Network Rail Consultation Response

To:	Arun District Council
Date:	17-May-22
Application reference:	BN/11/22/OUT
Location:	Barnham, Eastergate, Westergate BEW Parcel SC1 Barnham
NR Position:	More information required

Figure 2.1 Watercourse Location Plan including Site Observations

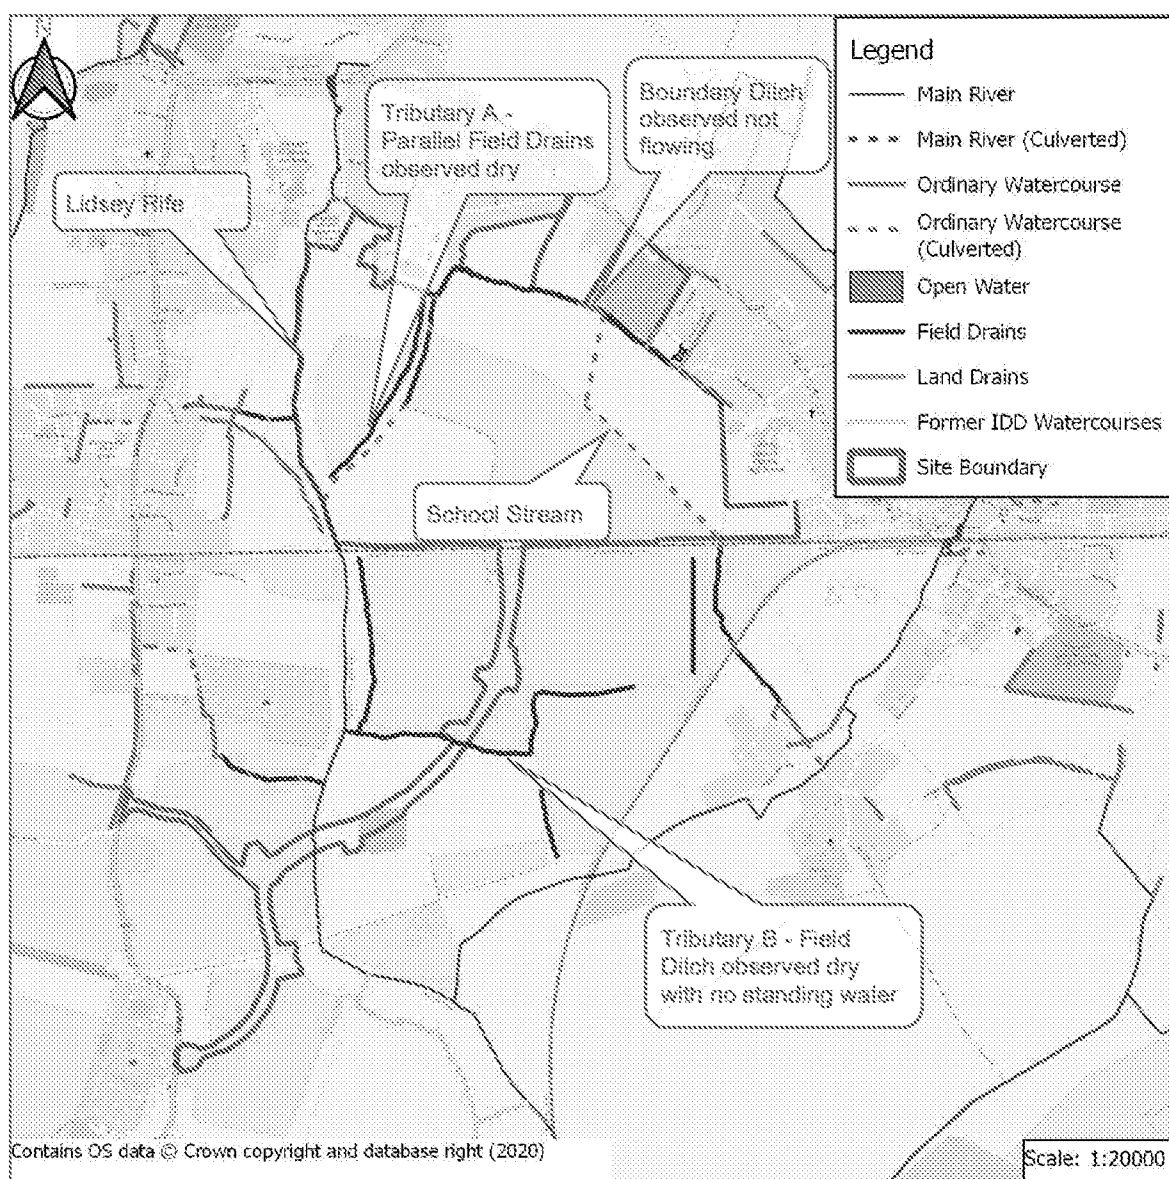
Based on the Composite Drainage Plan referenced above, there are a number of formal outfalls into the ordinary watercourse that runs along the eastern boundary of the site. With the proposed new link road and these formal outfalls into a more concentrated section of ditch (when compared to the existing scenario), we will need to see evidence that the proposals are either not increasing the flow into the ordinary watercourse or that the approved increase (subject to land drainage consent as noted by the Arun District Council Drainage Engineer) has been assessed. This is to determine if the downstream culvert, which runs beneath the railway at W3W: [///poem.unable.daisy](https://poem.unable.daisy) (<https://what3words.com/poem.unable.daisy>), has the capacity to deal with the additional flow. This assessment should also be undertaken for the river culvert along the western boundary, this

Barnham Station Link Section

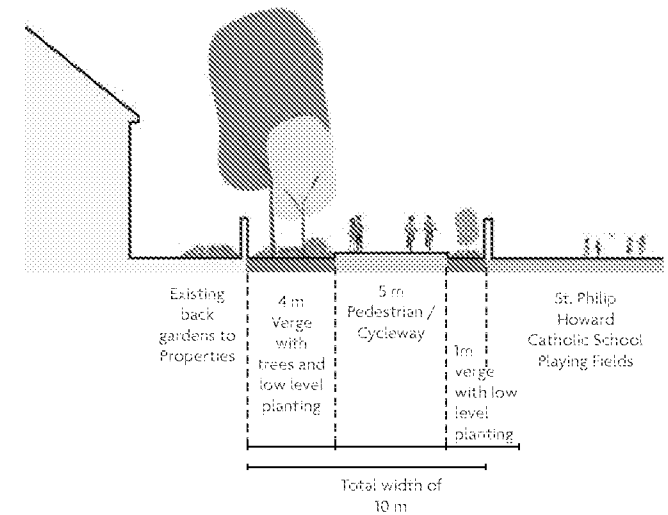
Network Rail welcome the proposal to improve the access to Barnham Station by way of a dedicated pedestrian and cycle link. Ideally it should be continuous and connect right up the station, not ending at Gospond Road.

Please could the applicant provide more information on the pedestrian and cycle link and how it connects to Bosham station.

OS Ref:	Structure Type: Over Flood plain	ELR/Mileage:
Drawn	Name	Date
Designed	AK	16/10/2020
Checked	AK	16/10/2020
Approved	AK	16/10/2020
Drawing No.	13394-PEF-ZZ-XX-M2-S-000003	Revision
		P07

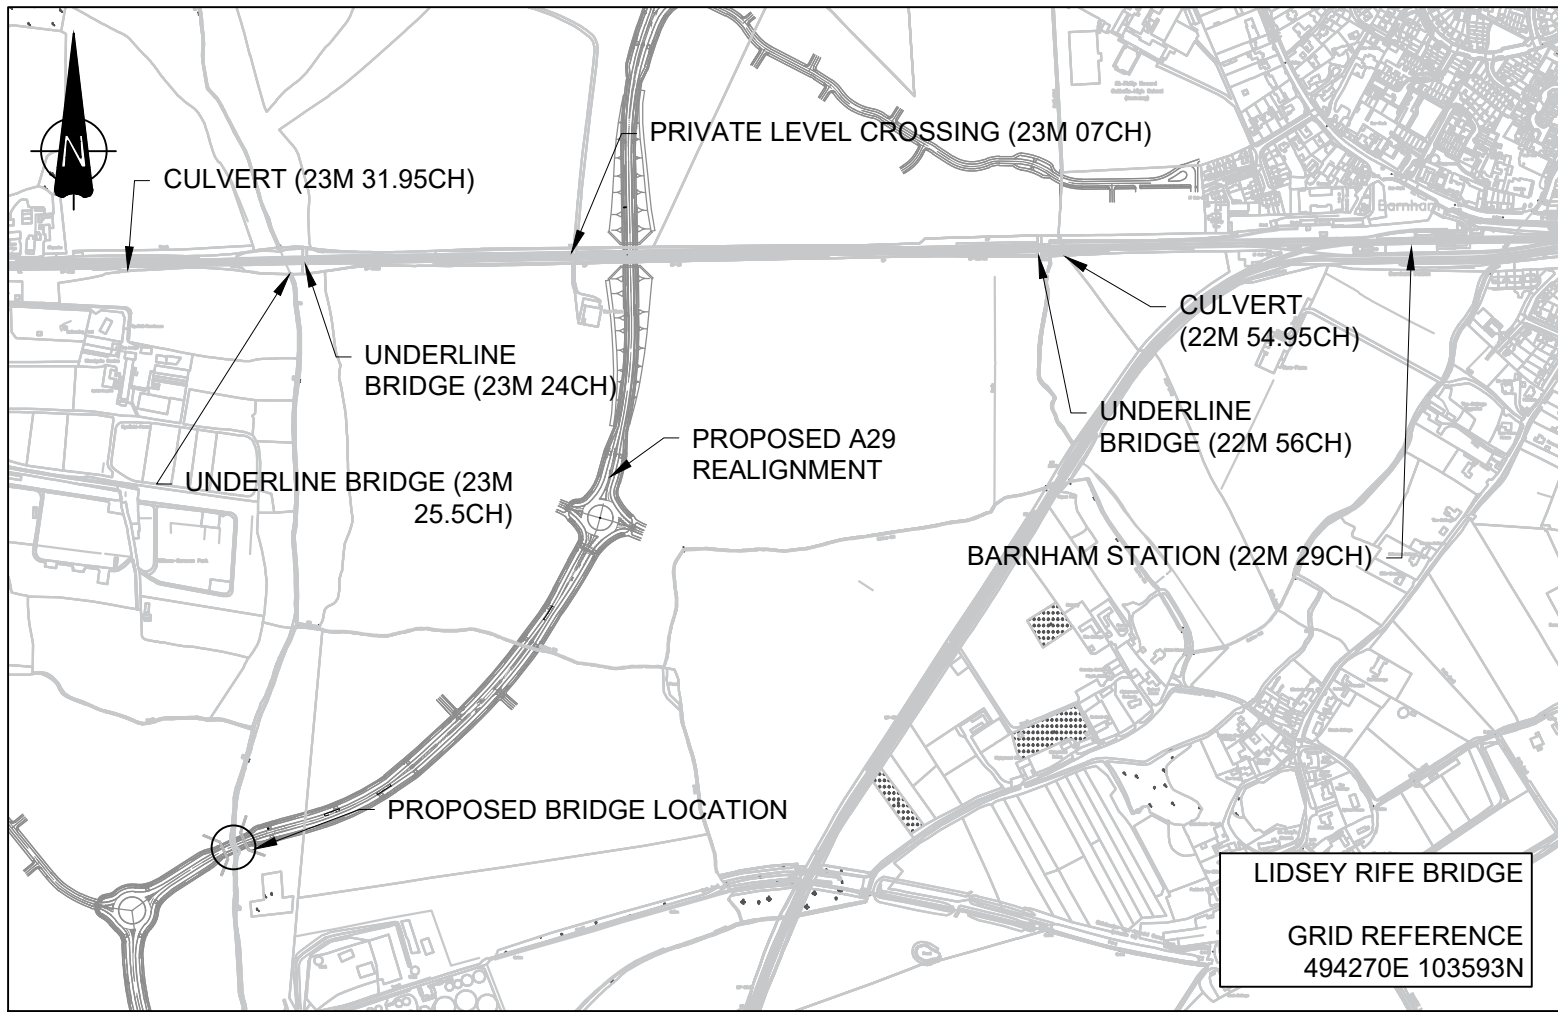
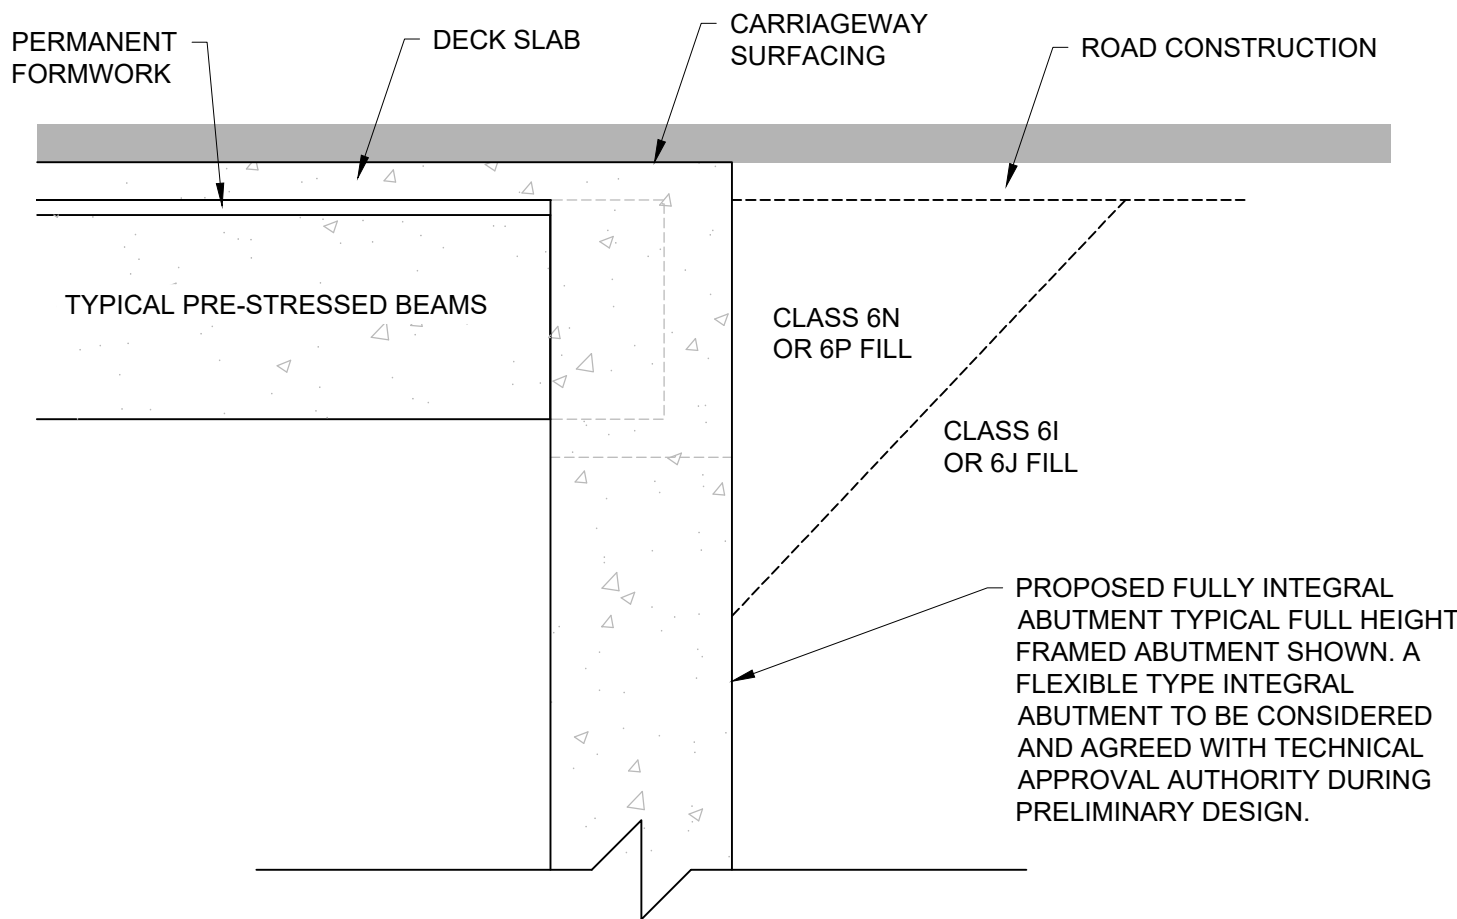
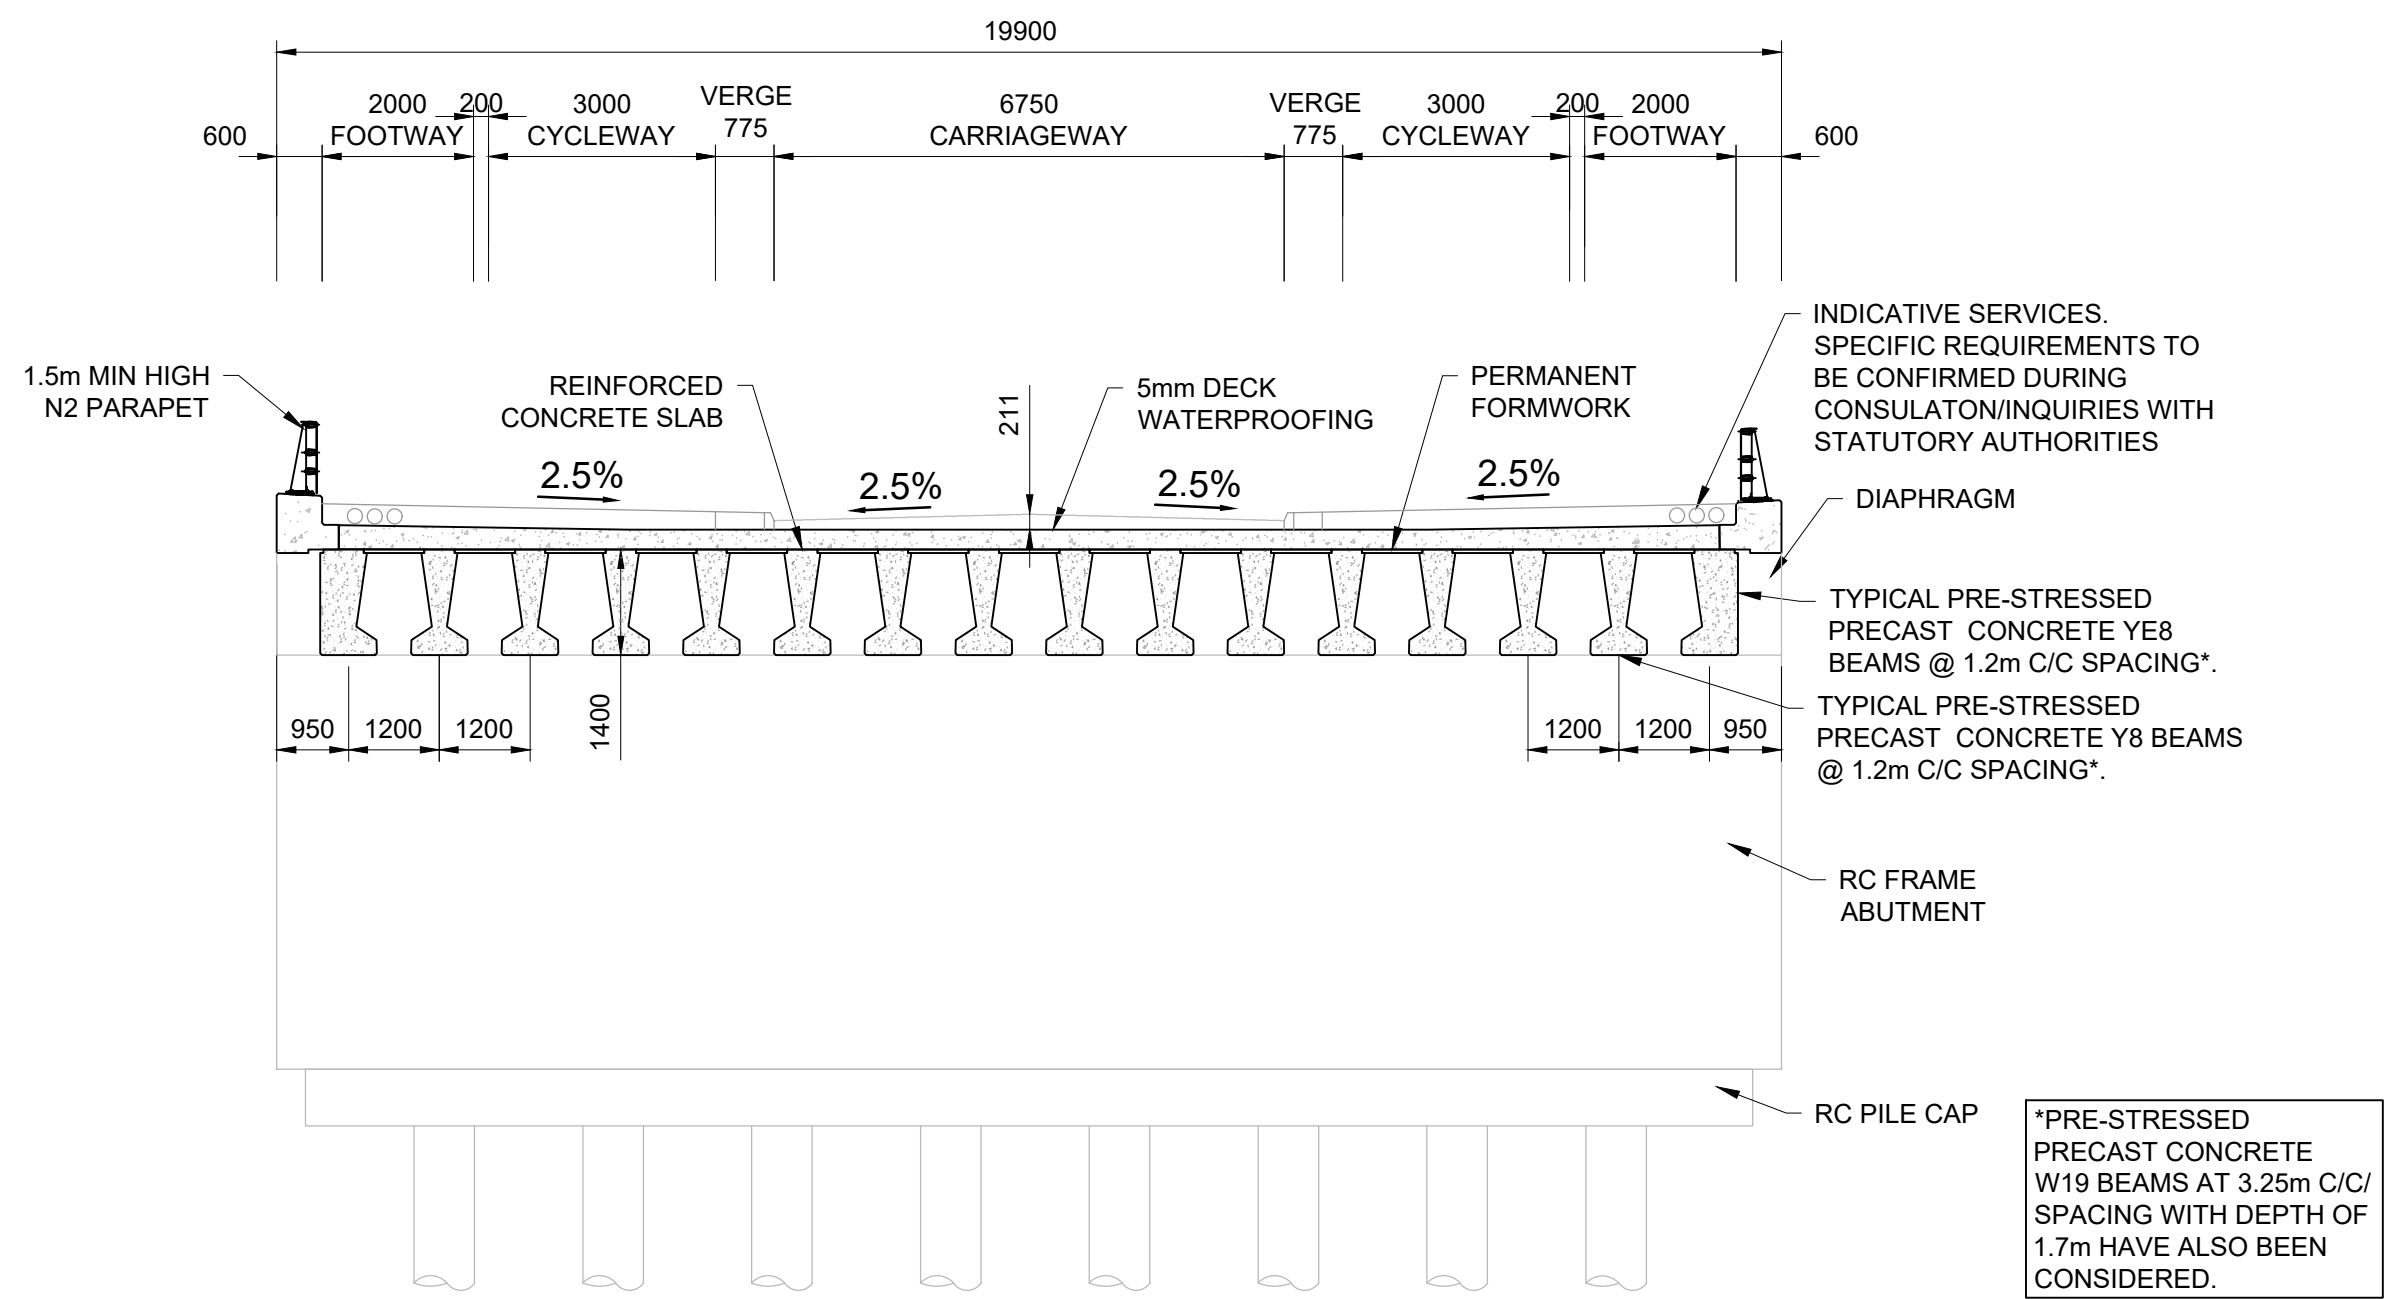
Each of the points raised above for the residential drainage are also pertinent for the link road drainage. We note that there is no proposed drainage over the track/Network Rail boundary, with a system of pipes and gullies taking runoff from both ramps north and south respectively. We have a network of track drainage here with some earthwork's drainage in the vicinity so we will need to ensure that the construction of any bridge over NR land has no detrimental impact on our assets.
